## **KIRTLINGTON PARISH COUNCIL**

8<sup>th</sup> November 2023

**Re. 23/02338/O – Land West of Oxford Close and North of Corner Farm, Station Road, Kirtlington**  
*Outline permission for the erection of 15 detached and semi-detached single and two storey dwellings (including affordable housing)*

Drawing Title:
 PROPOSED
 SITE PLAN
 COLOUR
 (ILLUSTRATIVE)

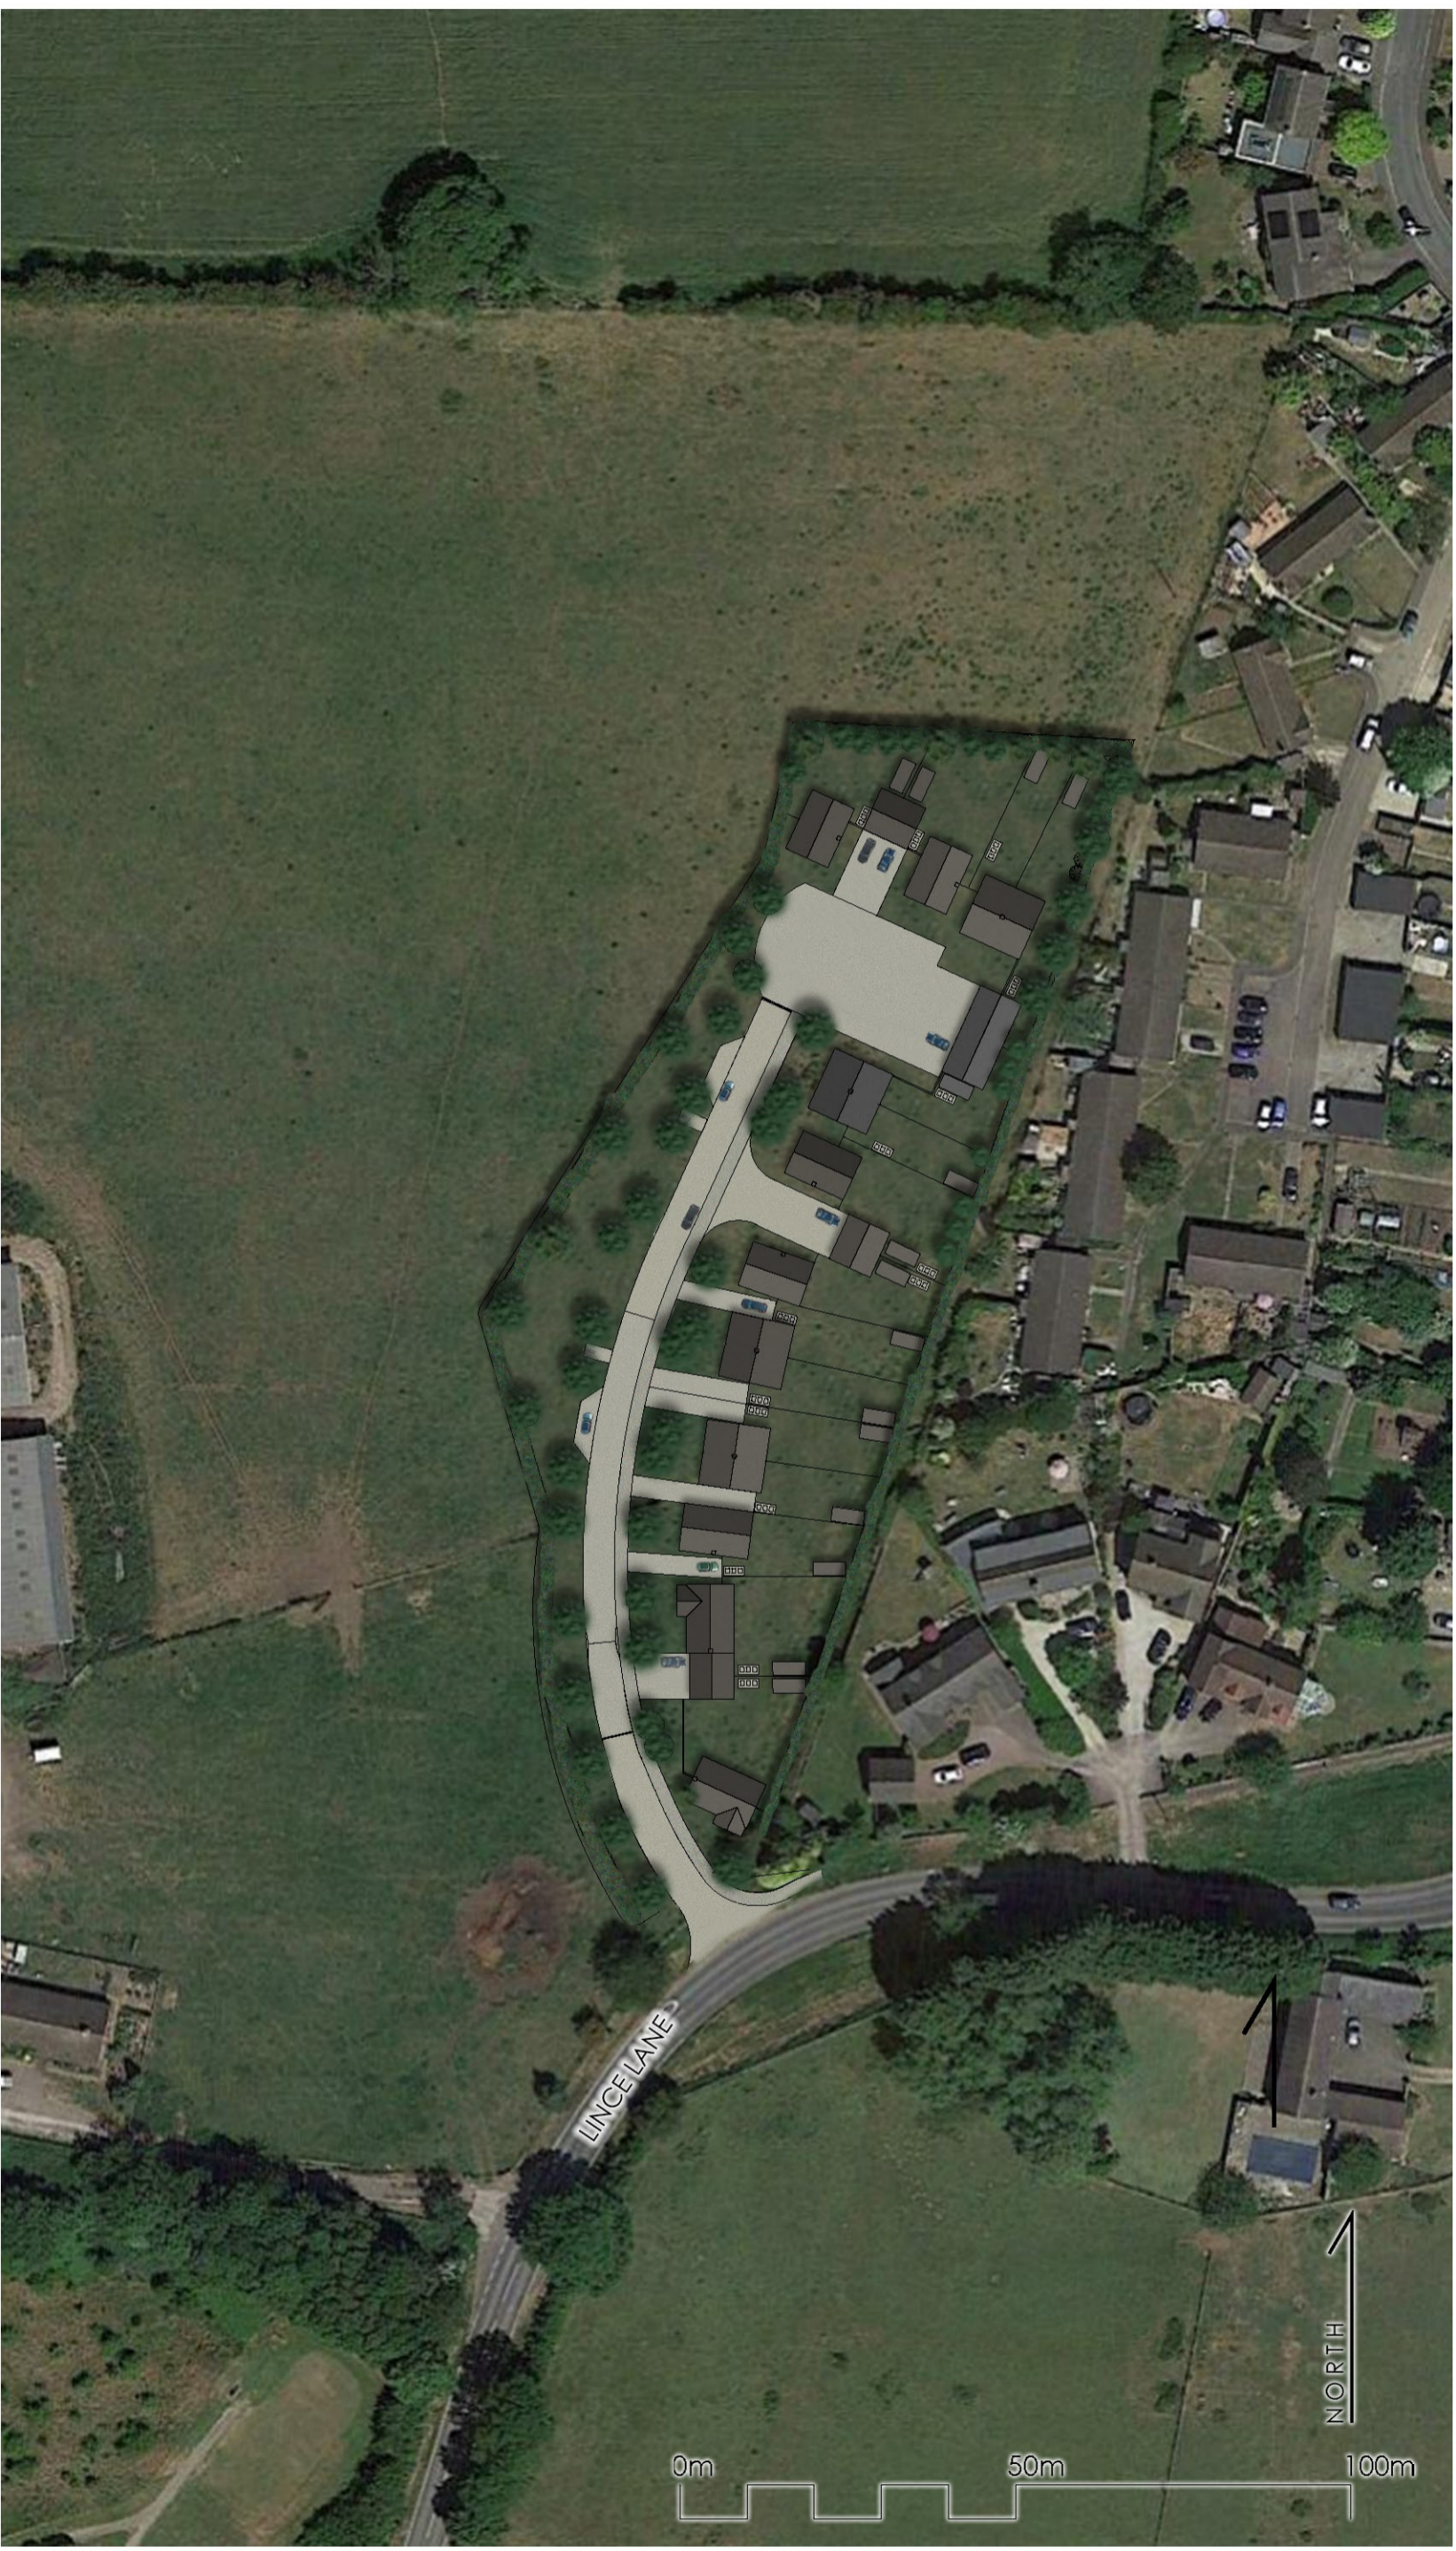
KPC considers any development at Corner Farm would lead to harm to the village, and whilst revision to the scheme to add social housing is welcomed, this should not be at the expense of housing density. Doubling the number of houses within the same application boundary has led to the extra houses being crammed in, side by side into the previous layout, with residents' car parking now inconveniently located in a line, bumper to bumper. The housing density proposed is now too high and out of keeping with adjacent development. Bike sheds have been added, to comply with OCC requirements, but these have been inconveniently located at the far ends of gardens, where they compound the problem of enclosing the existing PRoW.

TITLE:  
**Proposed Site Access -  
Vertical Visibility Splays**

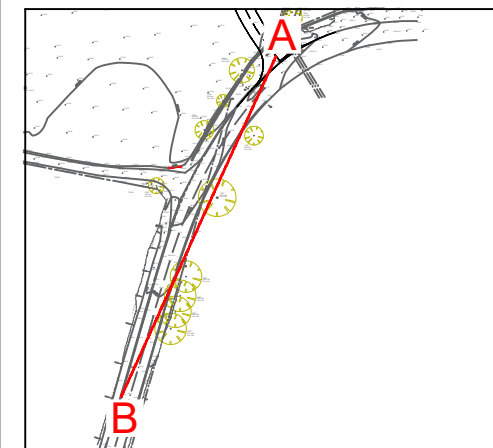
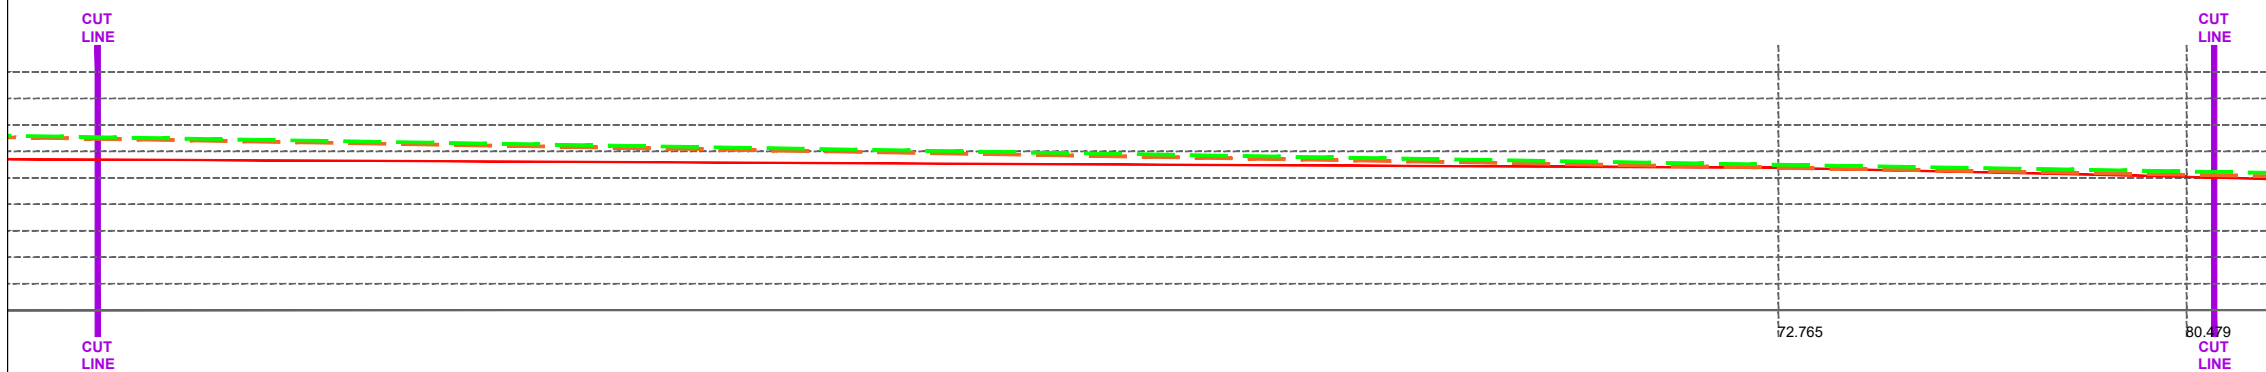
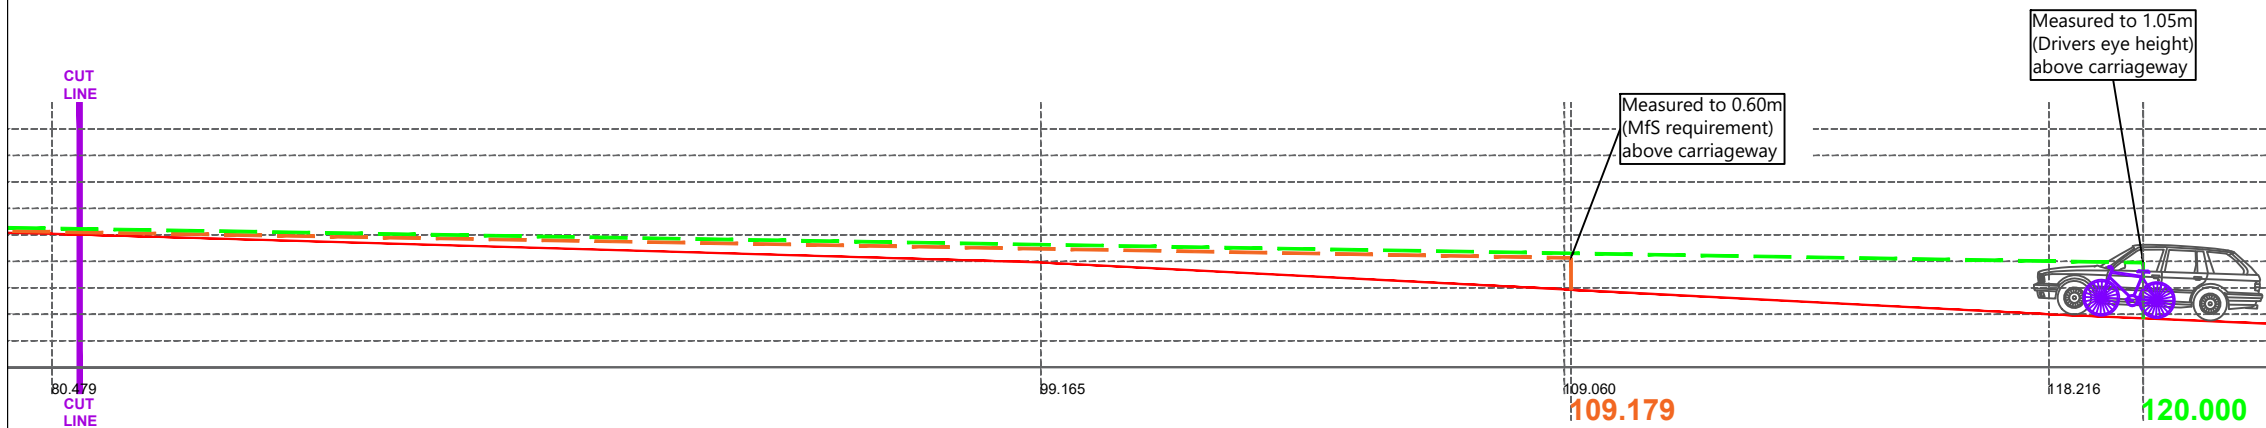
- 4) KPC has always voiced concerns regarding the access to this site. It is evident that adequate sight lines cannot be achieved, due to the sharp bend in the road and the gradients on the approach to the proposed access, and this could not be remedied without major interventions, such as considerable lifting of road levels around the proposed junction.
